Client
SPALDING RECTORY PARISH

Project
EXTERIORS TO FORM PARISH OFFICE
AT THE COACH HOUSE
HARREL COTE
SPALDING, Lincs.

Drawing
Plan & ELEVATIONS AS PROPOSED

PLAN & ELEVATIONS AS PROPOSED

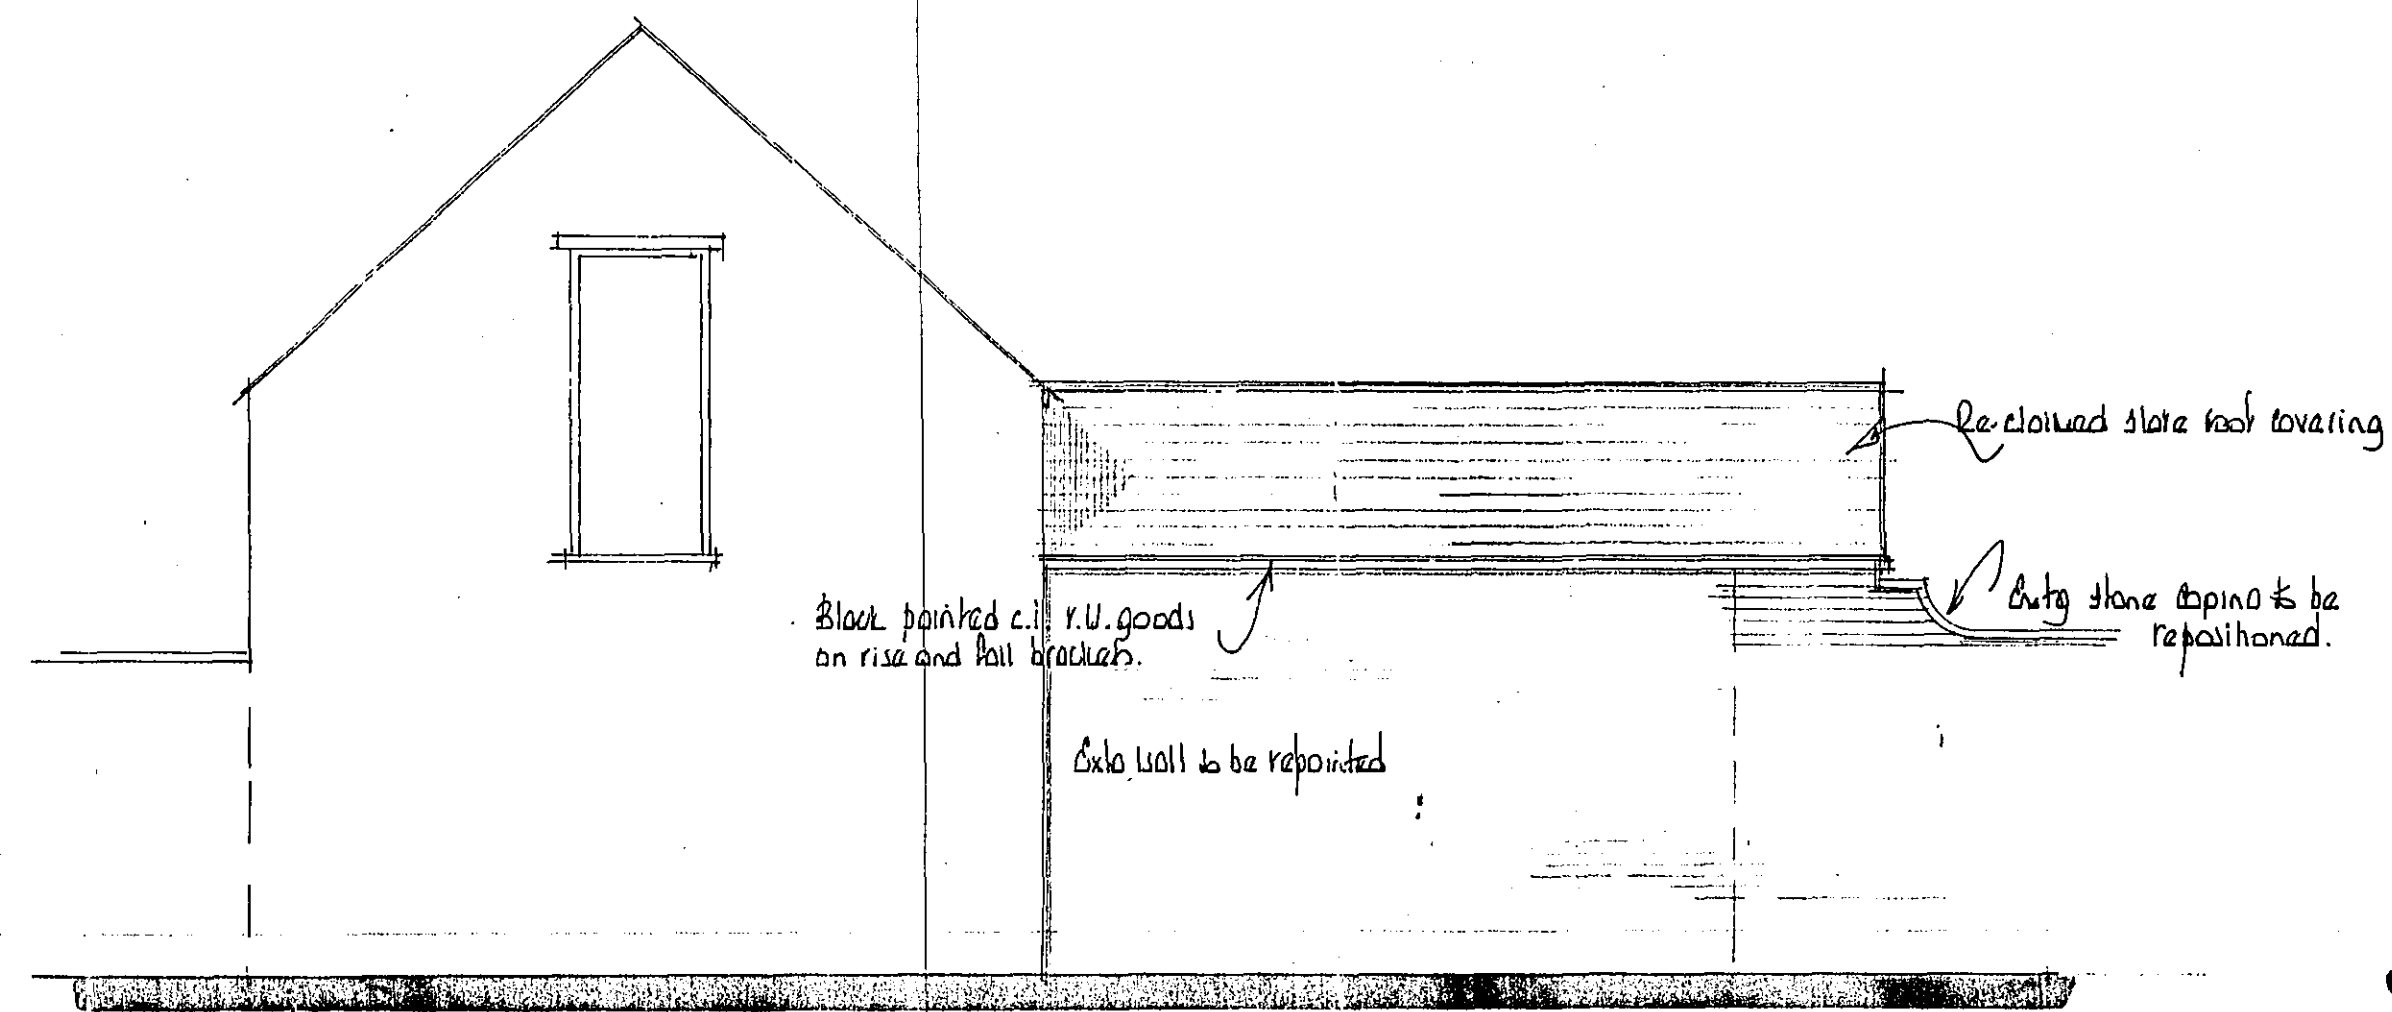
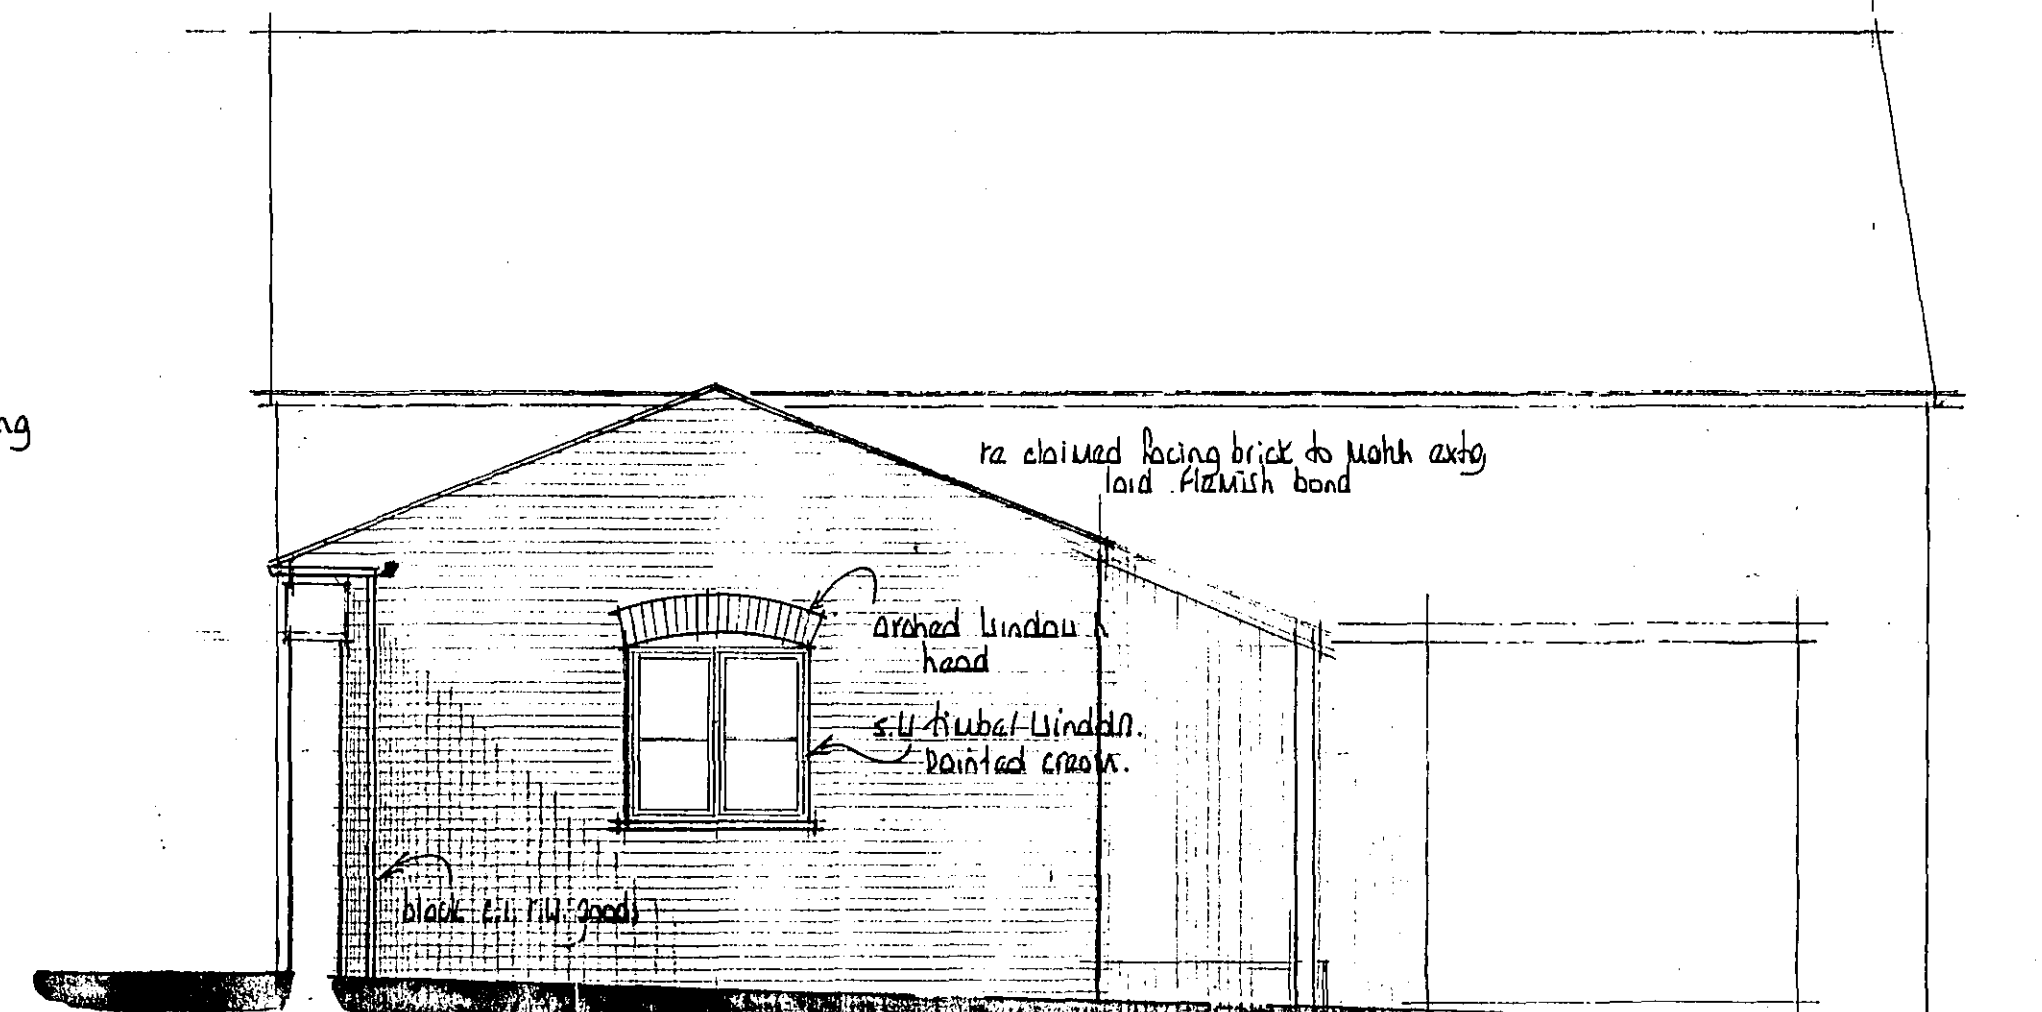
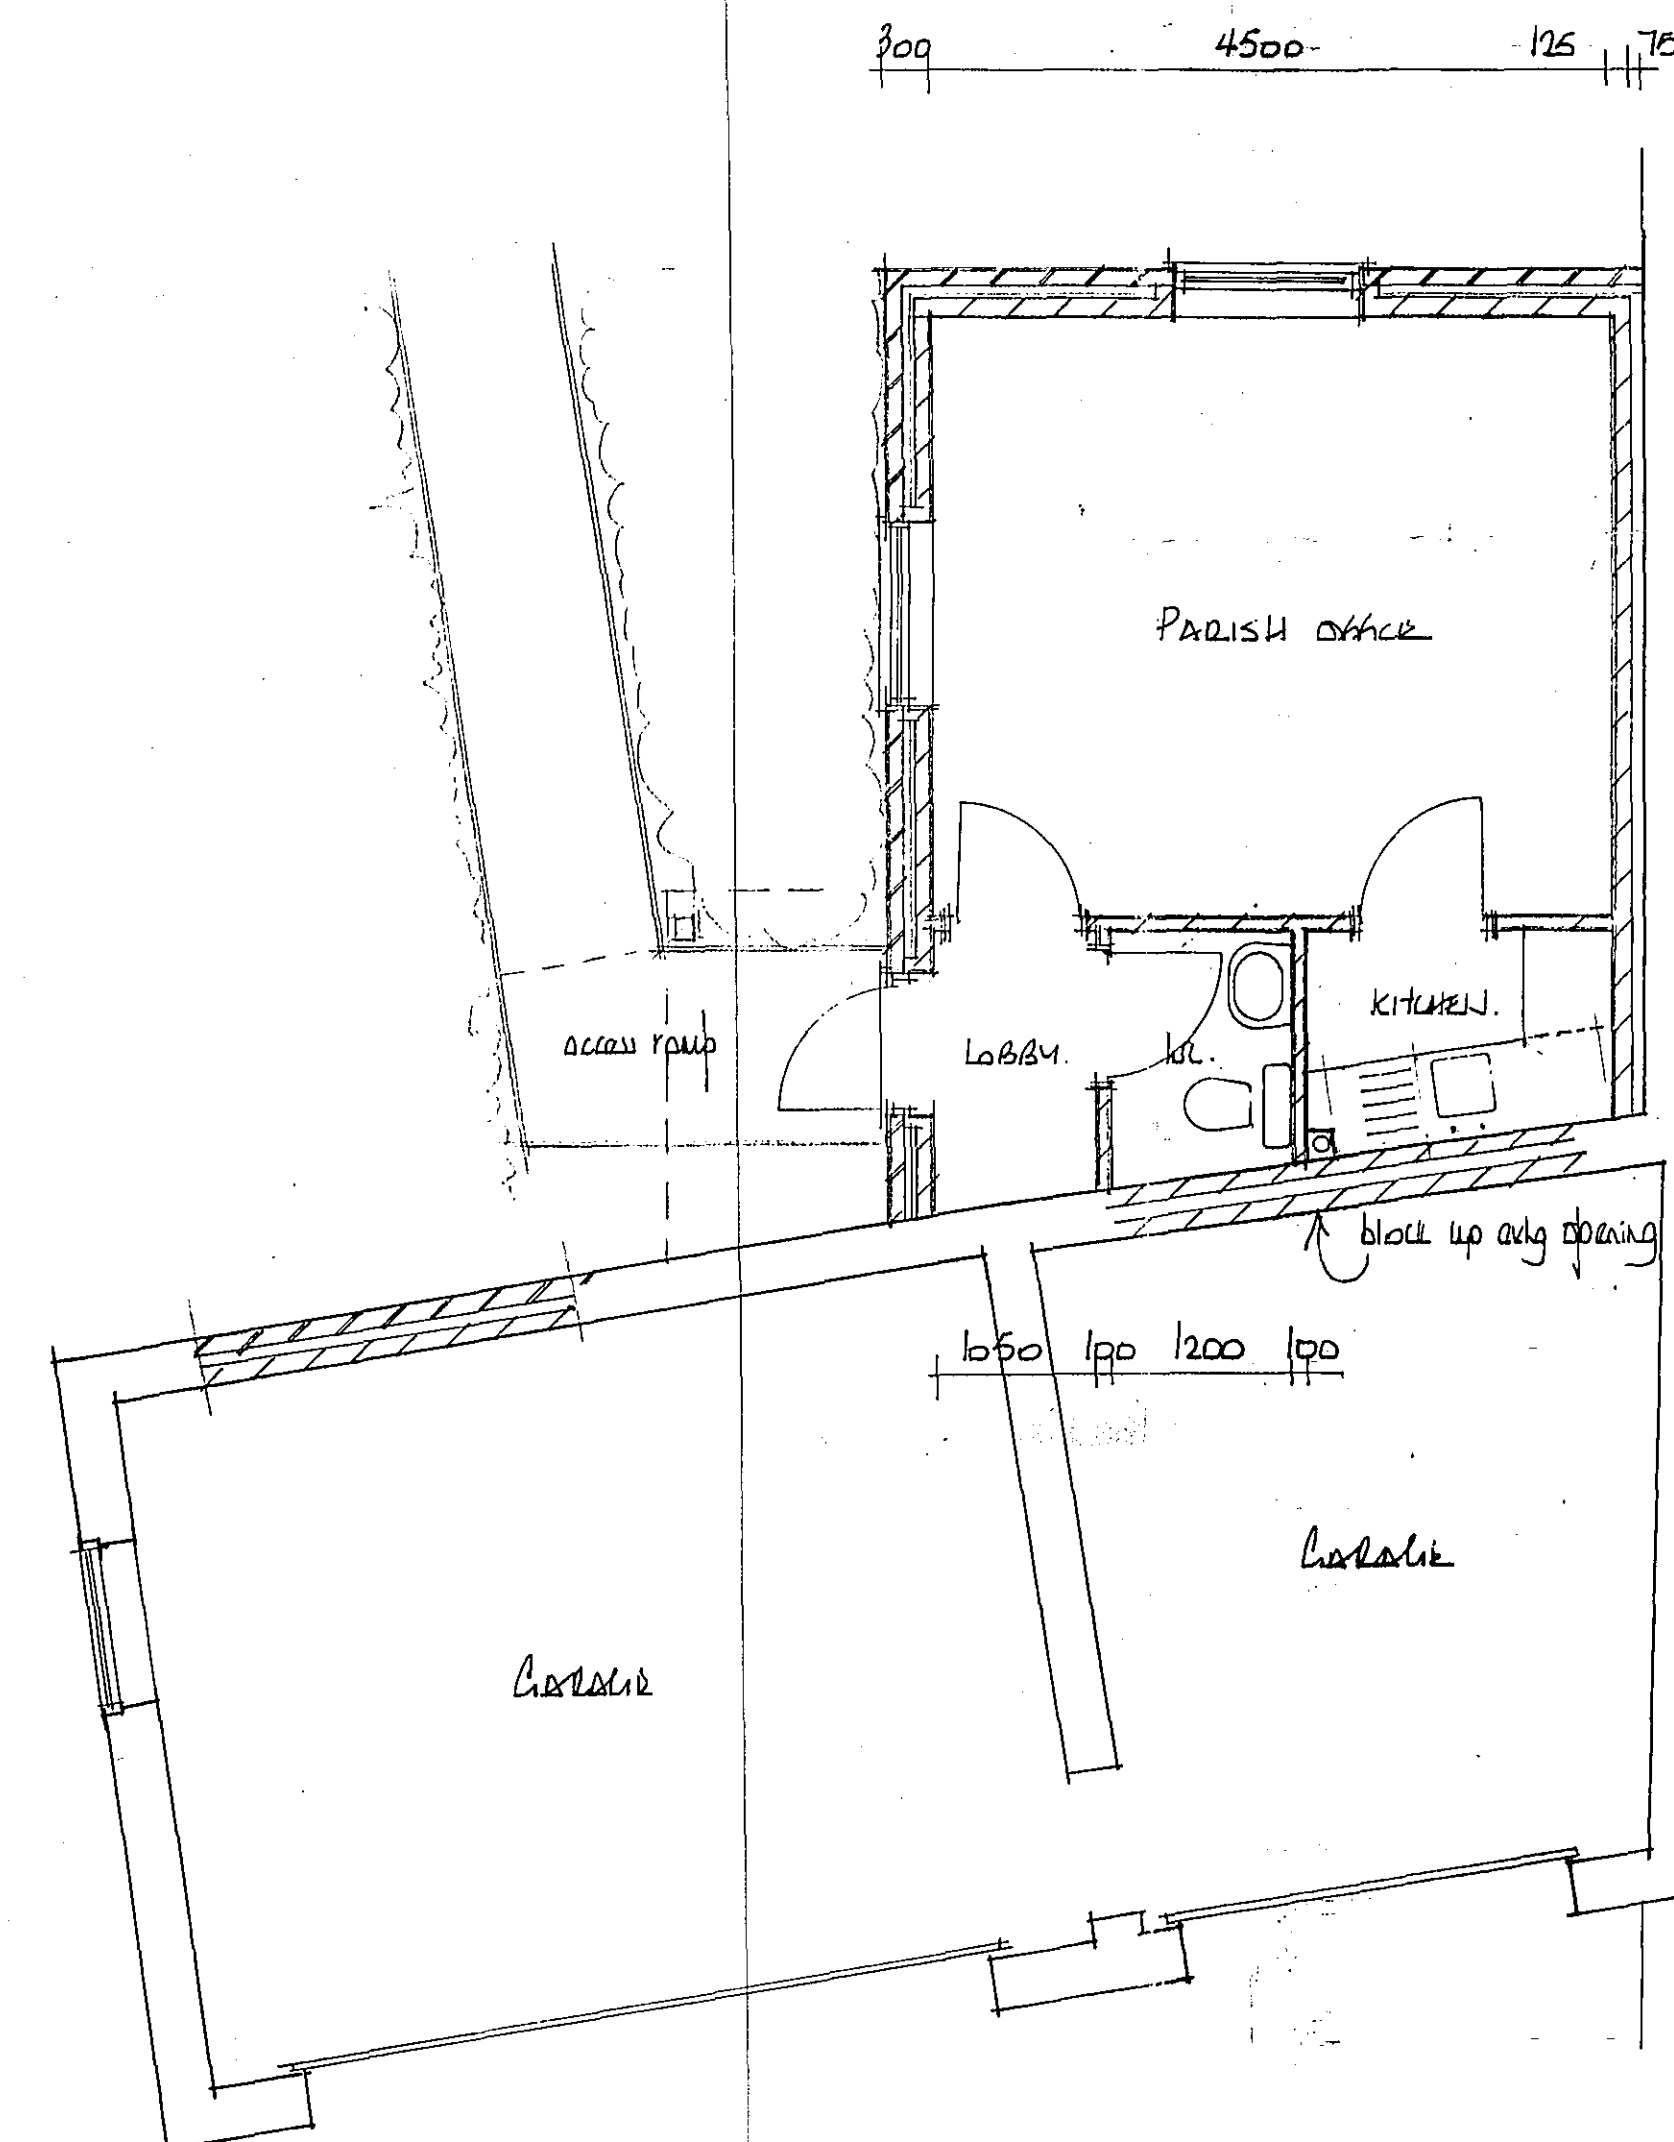
of West window!!
+ arch
to Ruler!!
rest of the

John
Plan left for
your consideration / comment
by Andy Lowrie
17/2/05
